Attachment A - Detailed response to all agency submissions including DPIE													
Issues Raised by Agency Submissions	Proponent's Response												
Department of Planning Industry and Environment (DPIE)													
General													
<p>The Department wishes to emphasise the importance of consistency and accuracy in terminology and naming throughout all documentation.</p> <p>There are several instances where items are incorrectly named (e.g. Belmont, Belmond, Elmont) throughout the report and figures do not add up (e.g. Table 4 (56+34=90, however the total presented is 88) and these generate confusion.</p> <p>The Department recommends a thorough review be undertaken of all documentation prior to formal lodgement.</p>	<p>It is acknowledged that there are two spelling errors (Belmond Road and Elmont Road) in the spelling of a street name in the EIS. The correct street name is 'Belmont Road'.</p> <p>It is also acknowledged that the calculation of total trees in Table 4 in the EIS is incorrect. The total trees on site under this SSDA should be 90. Note. This does not account for additional one (1) tree to be removed, which has been approved under separate REF approval. Refer

Image 1

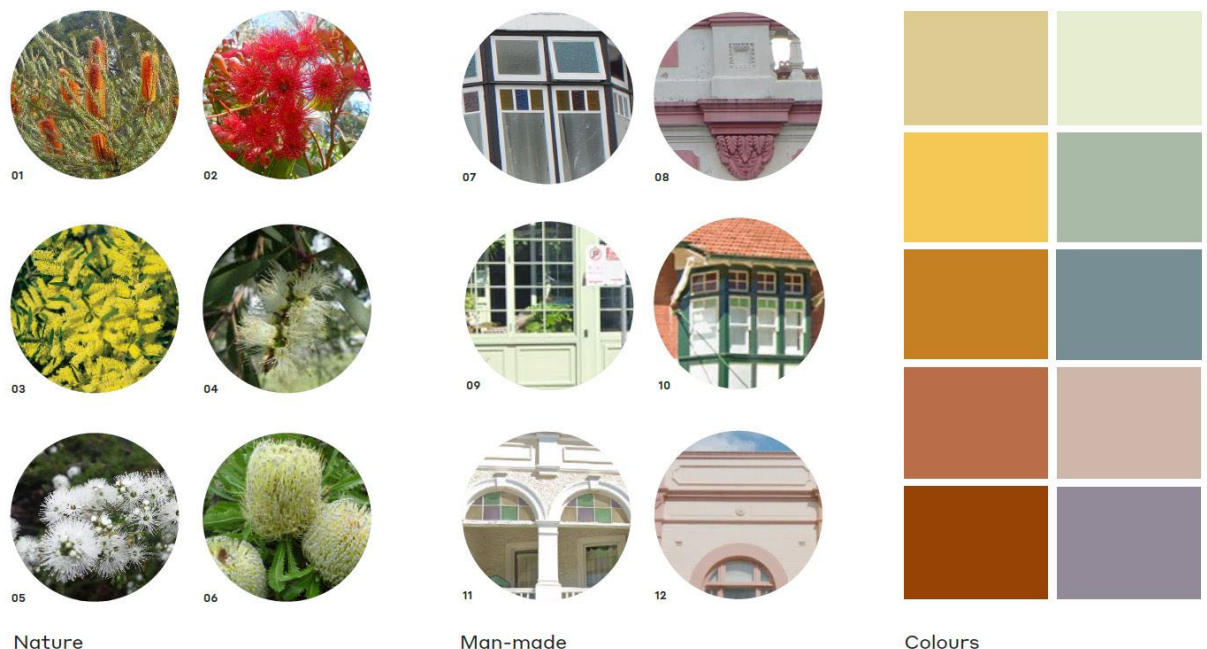
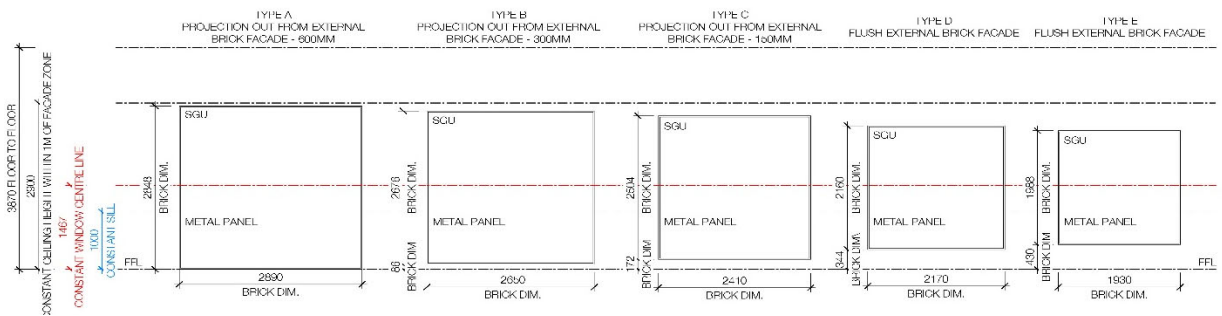
The façade design has responded to the built form recommendations by introducing colour and varied window reveals to express a more playful quality. While the playful quality is commended the irregular treatment and application of colour, window size, height, proportion and reveal treatment lacks an underlying logic and does not relate to the internal program.

It is recommended that the façade composition provide more disciplined approach to the application of the playful façade elements and articulation, to achieve a balance between its playful qualities and civic presence.

Playfulness of the varied window size and colours contribute to the façade articulation along Military Road. The value proposition for the window arrangement was not to relate directly to the room use but for any use now or in the future. The brief requirement was for "flexibility for the future" and the response therefore was to create the building as a vessel for many learning environments. These will change in the future depending on pedagogy shifts and school curriculum requirements.

A clear design logic has been followed for both colour selection and sizing.

*The variety of colour originates from both the natural and built landscape of Mosman. Being located in an area of vibrant native Australian nature and historic buildings, a wide range of colour has been pulled from the context to create a palette for the façade. Refer to image 1 below. (Note. Refer to **Attachment M** for high resolution of façade palette).*

Using the colours from the surrounding context, they have been applied to the window frames in a continuous way that changes hue as it wraps around the building. The experience of the building will vary depending on the location being observed. Further detail has been added by using a gradient to fade out the colour as it climbs up towards the top level of the building.

The colours have been adjusted, muting them further to decrease the intensity while retaining the colour scheme and its playful nature.

Figure 3 – Exit Route via Belmont Road

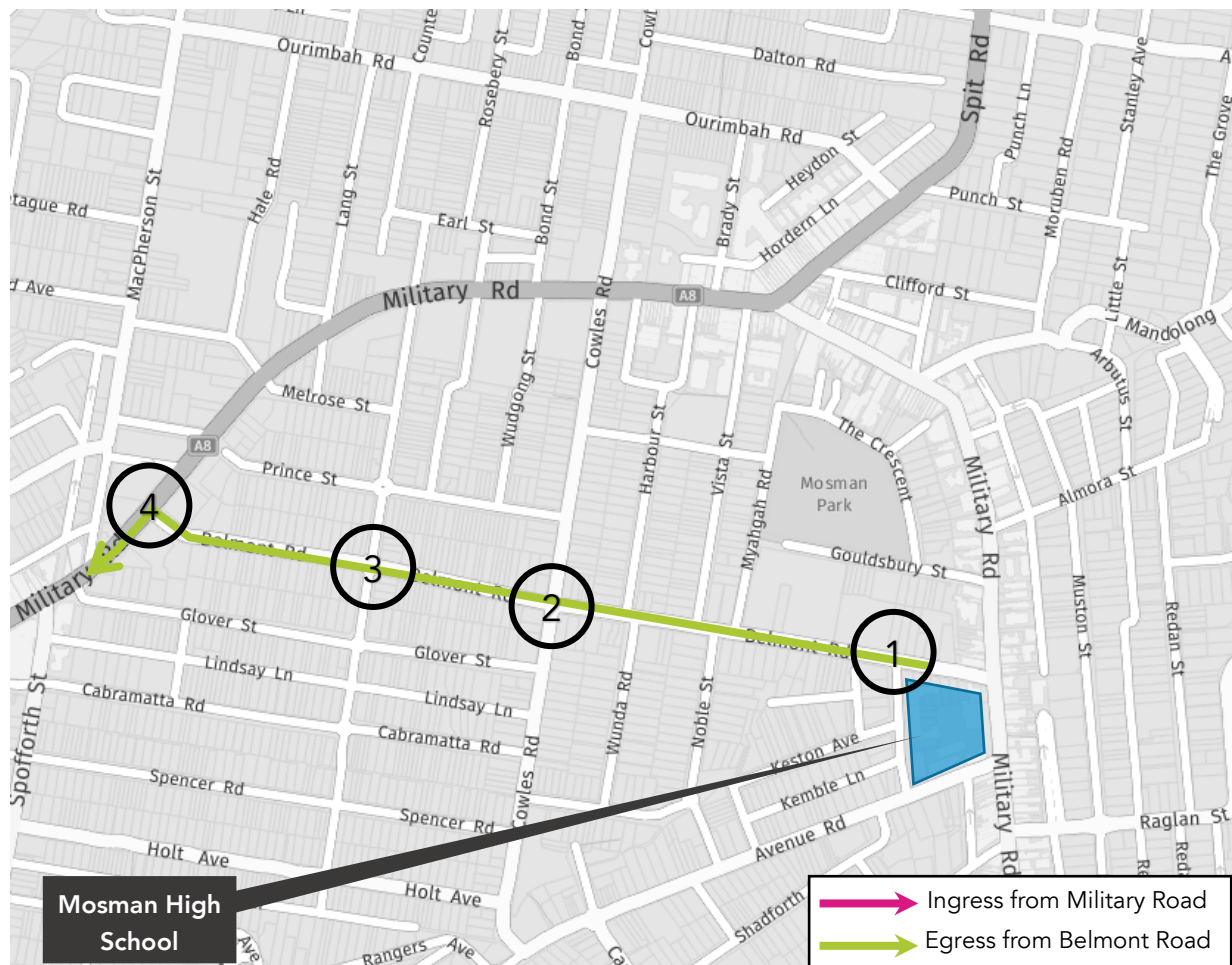
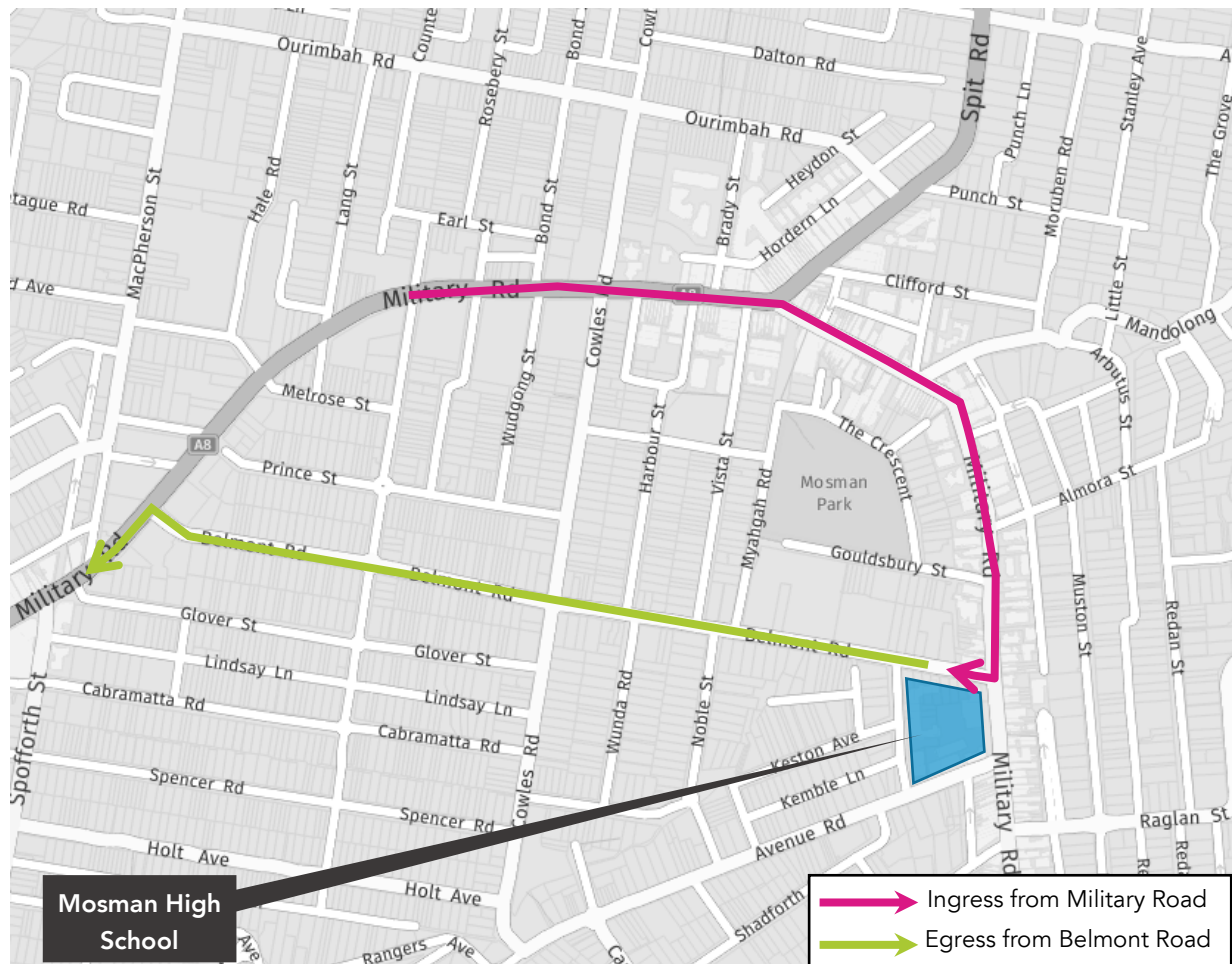
<p><u>Comment</u> The swept path diagrams within the CTMP are not clear enough for TfNSW to complete the assessment and provide comment.</p> <p><u>Recommendation</u> It is requested that the Proponent to submit the swept path diagrams in DWG format to TfNSW for review.</p>	<p>Refer to attached swept path diagrams provided by PTC consultants in DWG format for TfNSW's assessment, provided under separate cover.</p>
<p>Active Transport</p> <p><u>Comments</u> Current NSW policies state the importance of walking and cycling to increase access to local centres and integrating transport with land use as part of the whole customer journey. Future Transport 2056 emphasises the importance of walking and cycling for short trips and reinforces the importance of walking and cycling to increase the catchment of public transport as part of the whole customer journey.</p> <p><i>Building Momentum - State Infrastructure Strategy 2018-2038</i> includes recommendations related to walking and cycling, including integrating transport with land use; managing travel demand; unlocking capacity in existing assets; and improving population health outcomes through more active transport.</p> <p><u>Recommendation</u> It is requested that prior to the issue of the first Occupancy Certificate, the applicant be conditioned to provide bicycle parking and end of trip facilities for staff, students and visitors in accordance with Australian Standard AS1742.9:2018 Manual of Uniform Traffic Control Devices - Bicycle Facilities, and Cycling Aspects of Austroads Guides including:</p>	<p>PTC consultants provide the following response (as per Attachment L):</p> <p><i>SINSW has deployed a process of school upgrades which involves a holistic review of measures that would help decrease the use of private vehicles and instead increase walking, cycling and public transport use to commute to and from the school.</i></p> <p><i>A Green Travel Plan has been prepared outlining measures to promote active and public transport and carpooling. SINSW is committed to implementing these plans across all new developments; A travel plan coordinator will be employed to coordinate the implementation of these measures and monitor the mode shift.</i></p> <p><i>As part of the above, this project proposes to provide bicycle spaces for students and bicycle spaces and an end of trip facilities for staff to promote active transport. Bicycle racks for students are accessible via Avenue Road and Gladstone Avenue. Cycling facilities are shown in Attachment 1 in the TIA.</i></p> <p>It is noted that while the proposed development is Crown Development, and as such, Occupancy Certificates do not apply. Despite this, the Applicant accepts the recommended condition of consent.</p>
